City of Portland, Maine - Building or Use Permit Application
 389 Congress Street, 04101 Tel: (207) 874-8703, Fax: (207) 874-8716

Permit No: 05-1433	Issue Date:	CBL: 342 B029001
------------------------------	--------------------	----------------------------

Location of Construction: 48 RUBY LN Lot # 11	Owner Name: CUSTOM BUILT HOMES OF MAIN	Owner Address: 35 MAIN ST.	Phone:
Business Name:	Contractor Name: CBHM Inc	Contractor Address: 35 Main Street Windham	Phone 2078923149
Lessee/Buyer's Name	Phone:	Permit Type: Single Family	Zone:

Past Use: Vacant Land	Proposed Use: Single Family Home/ Construct new 24' x 40' Split Level Single Family Home	Permit Fee: \$1,176.00	Cost of Work: \$120,000.00	CEO District: 5
Proposed Project Description: Construct new 24' x 40' Split Level Single Family Home		FIRE DEPT: <input type="checkbox"/> Approved <input type="checkbox"/> Denied	INSPECTION: Use Group: Type	
		Signature:	Signature:	
PEDESTRIAN ACTIVITIES DISTRICT (P.A.D.)				
Action: <input type="checkbox"/> Approved <input type="checkbox"/> Approved w/Condition <input type="checkbox"/> Denied				
		Signature:	Date:

**FIRST FLOOR PLAN**  
 Scale: 1/4" = 1'-0"

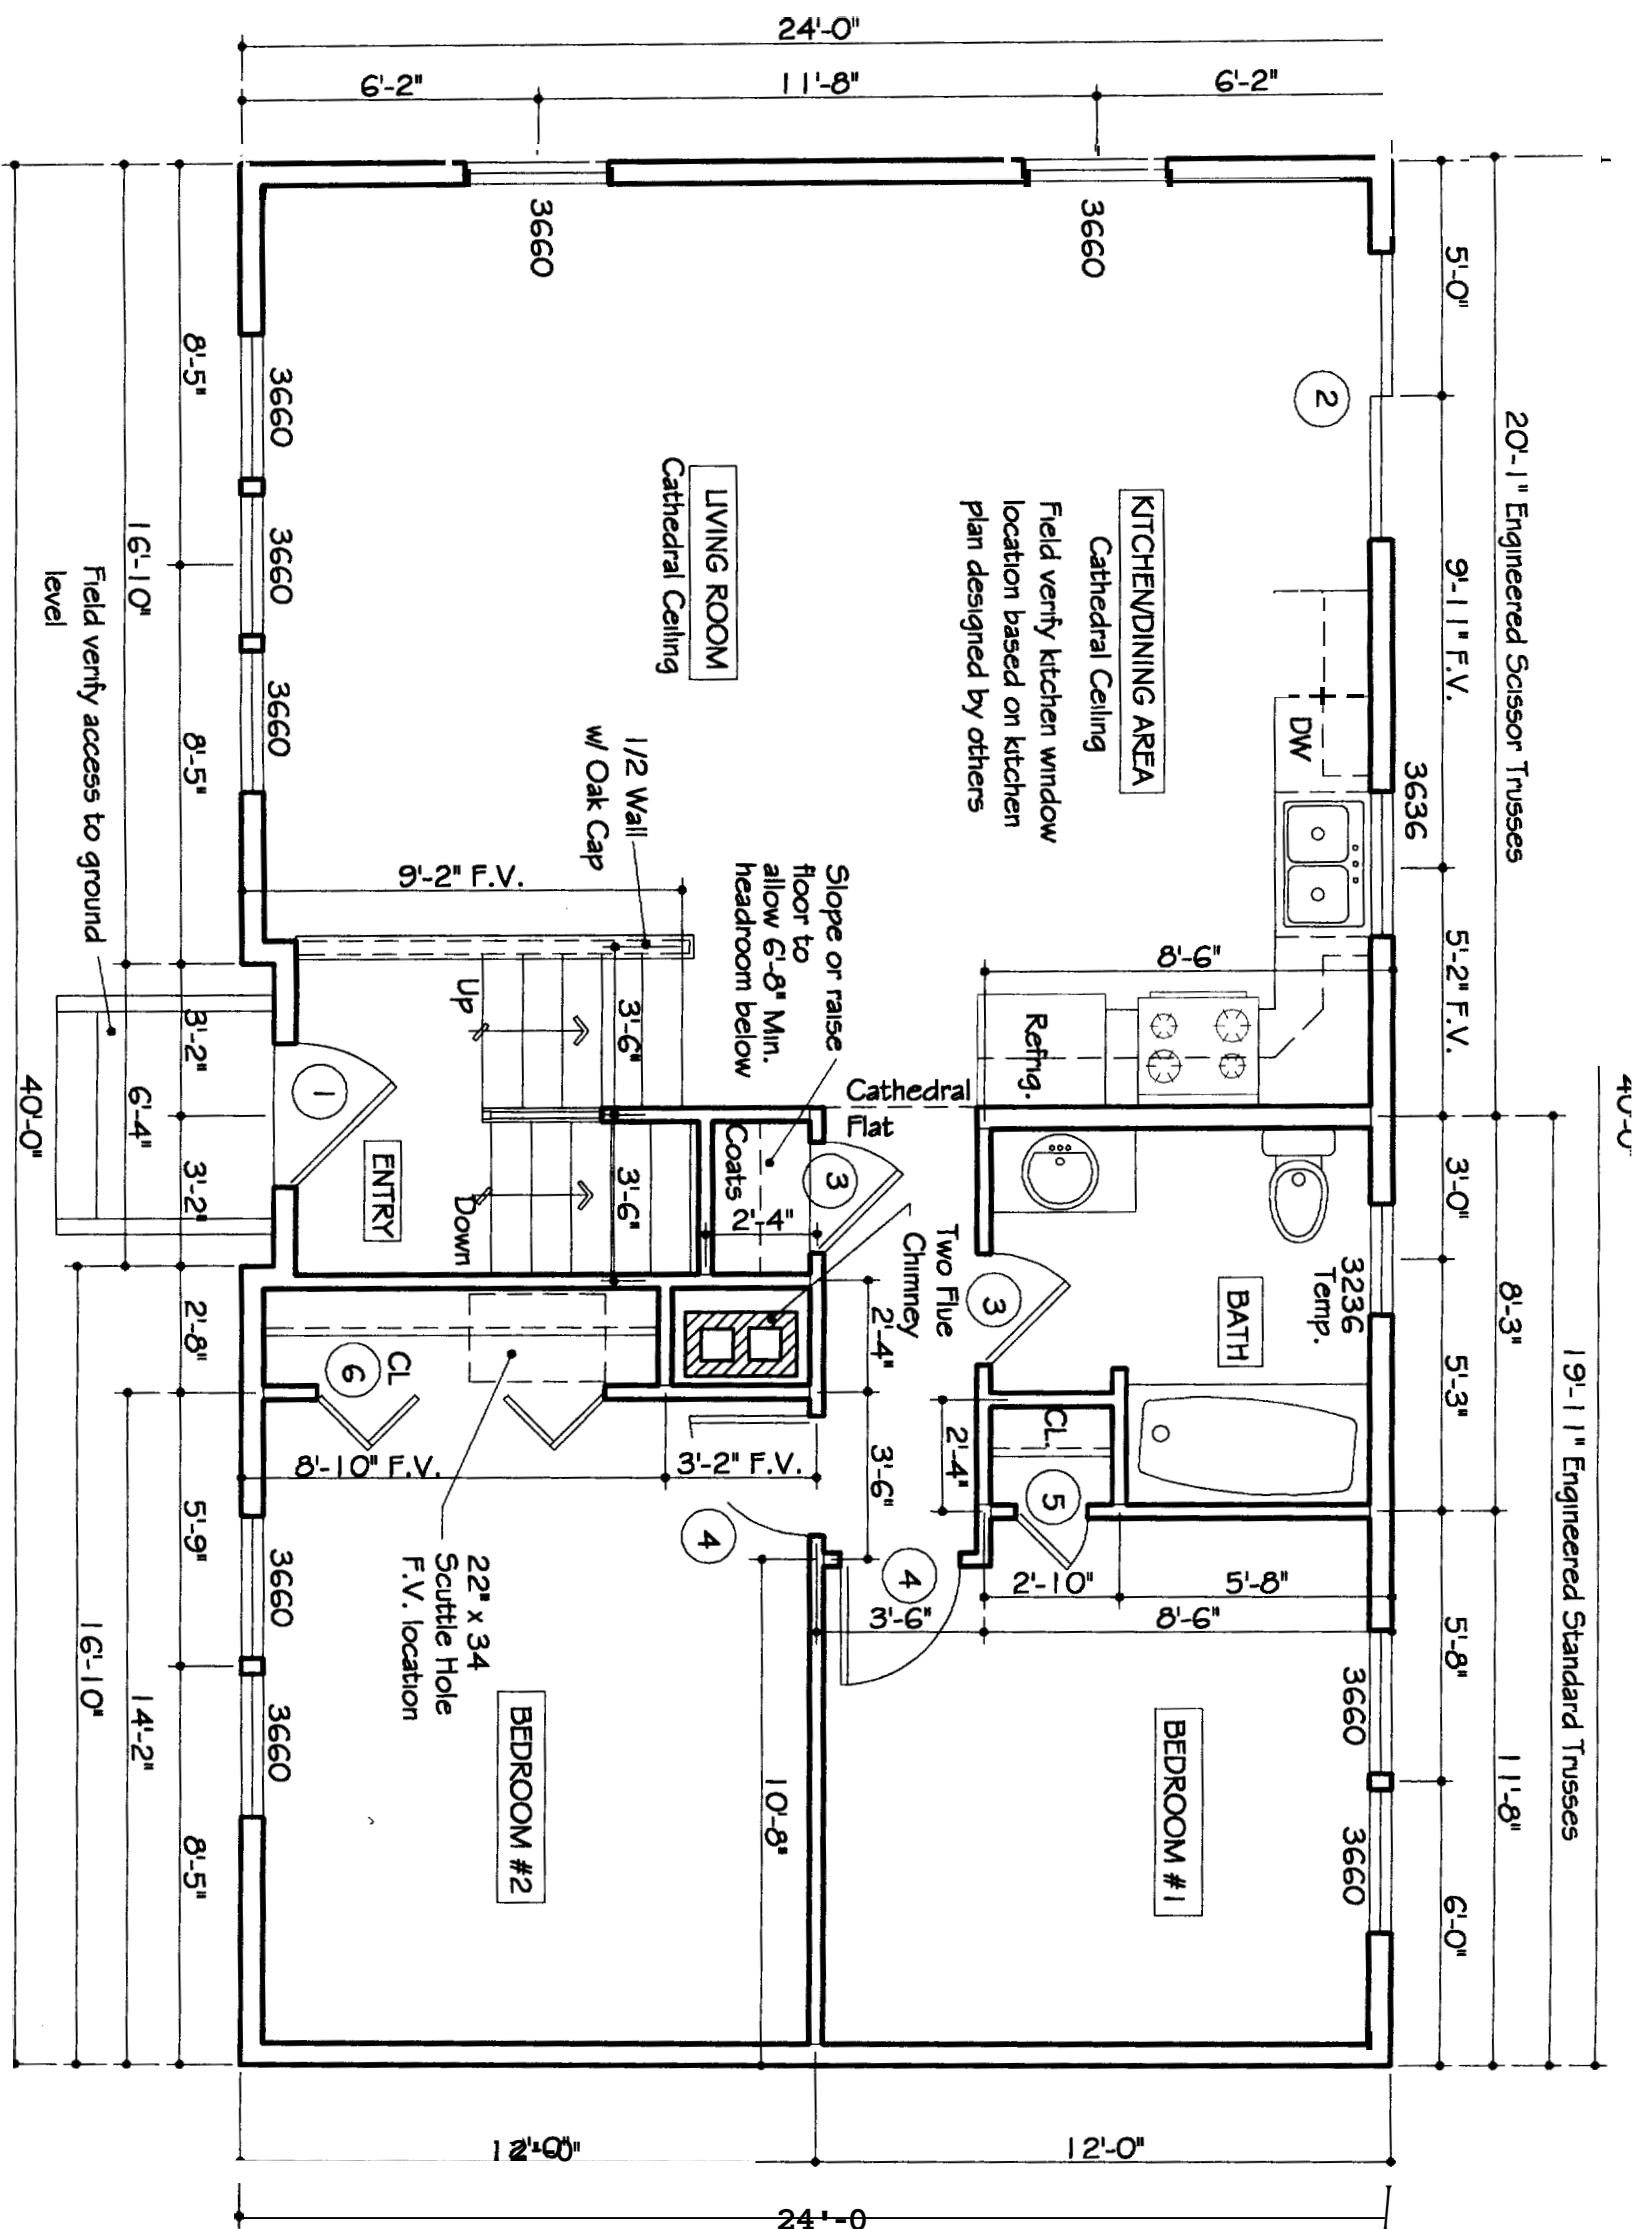
Note: 10/11/05 Talked to Ted . Told him we need scalable floor plans & revised site plan showing 2 parking spaces **Ok to Issue:**
past 25' front setback.

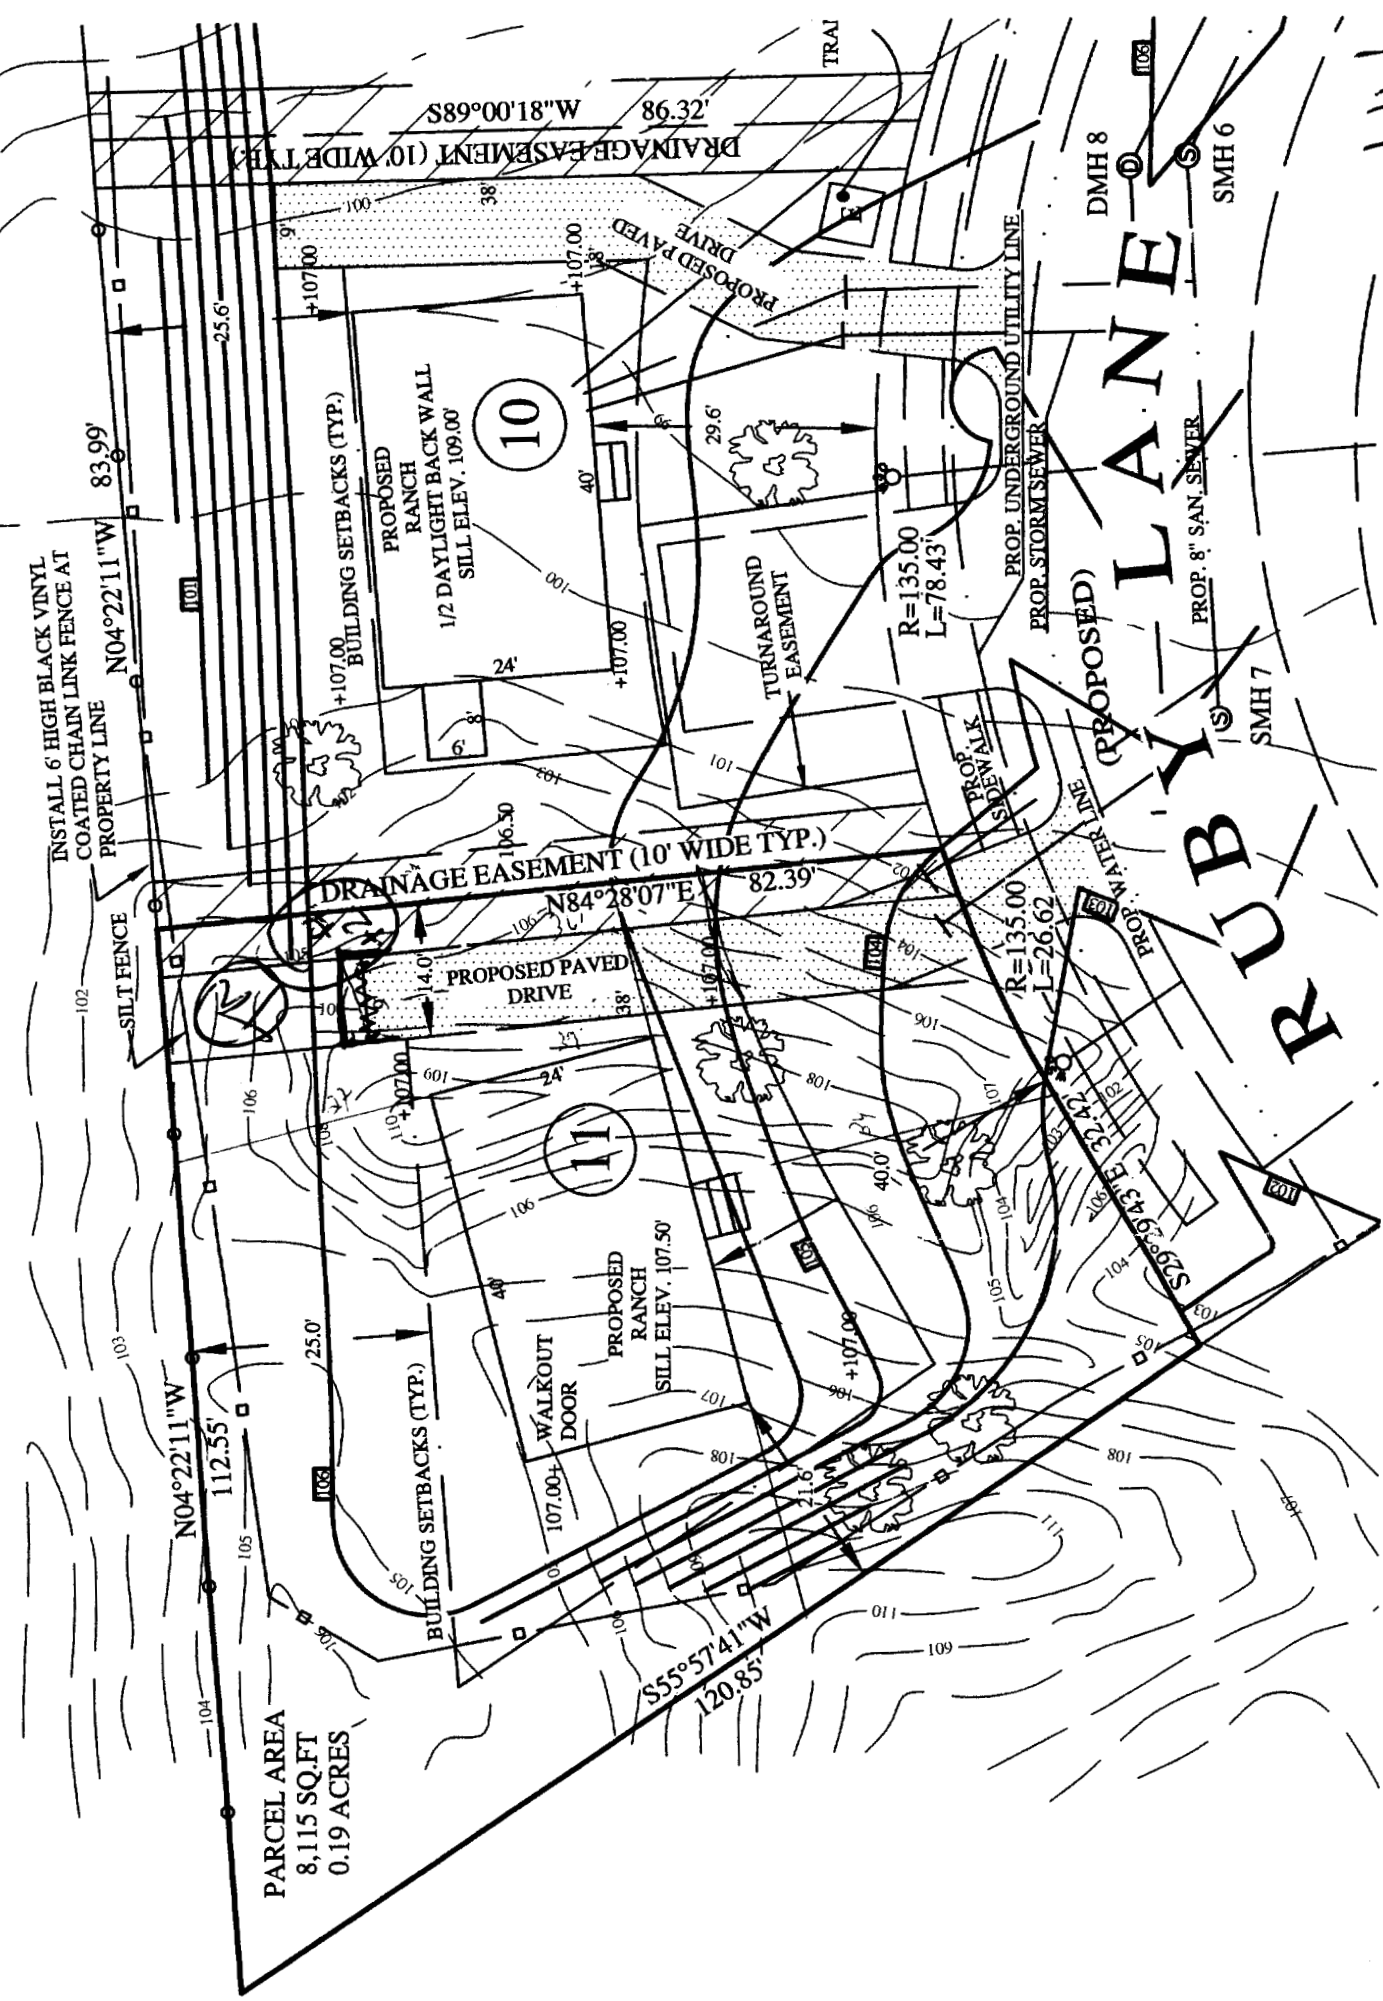
10/25/05 Message W/Ted. Needs to show two more feet of driveway on right side on site plan.
